Current Zoning: N1-A (neighborhood 1-A)
Proposed Zoning: N2-A (CD) (neighborhood 2-A, conditional)

Approximately 17.48 acres located along the south side of Johnston Oehler Road, east of Prosperity Ridge Road.

The petition proposes a residential community of up to 114 multi-family attached dwelling units.

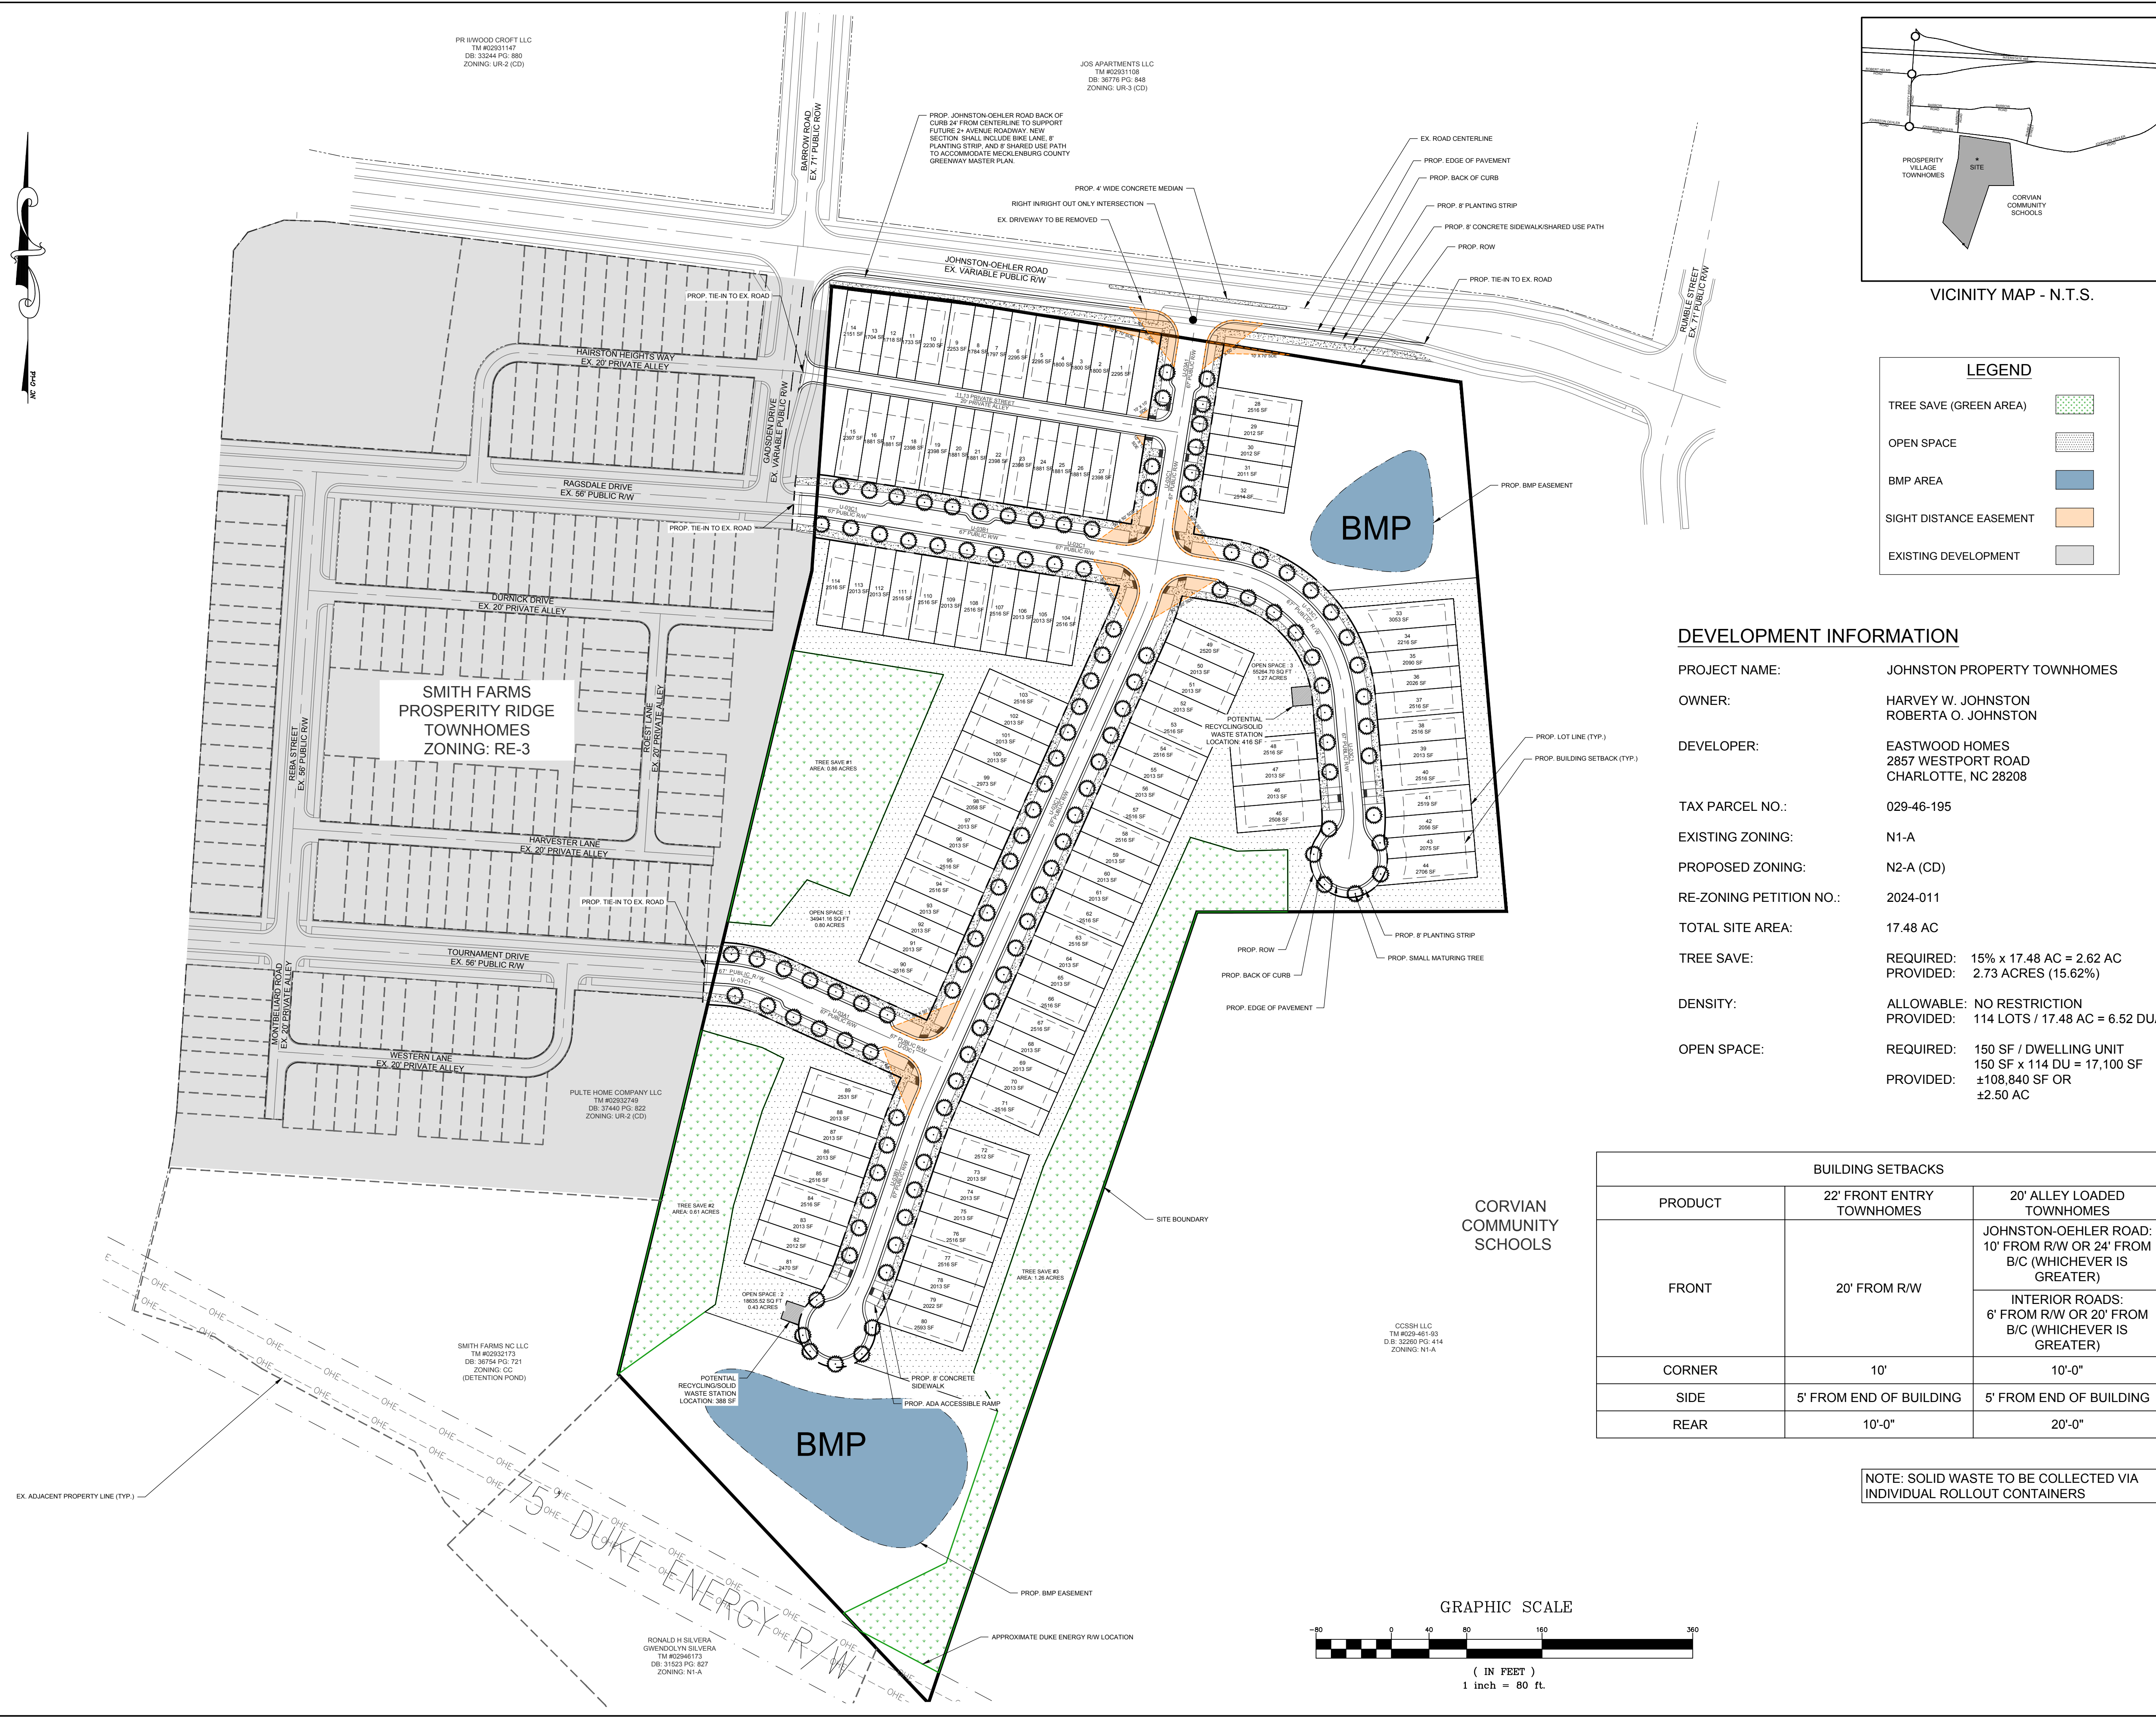
- ~~1. Add Comprehensive Transportation Review (CTR) table with offsite commitments to the site plan.~~
Addressed
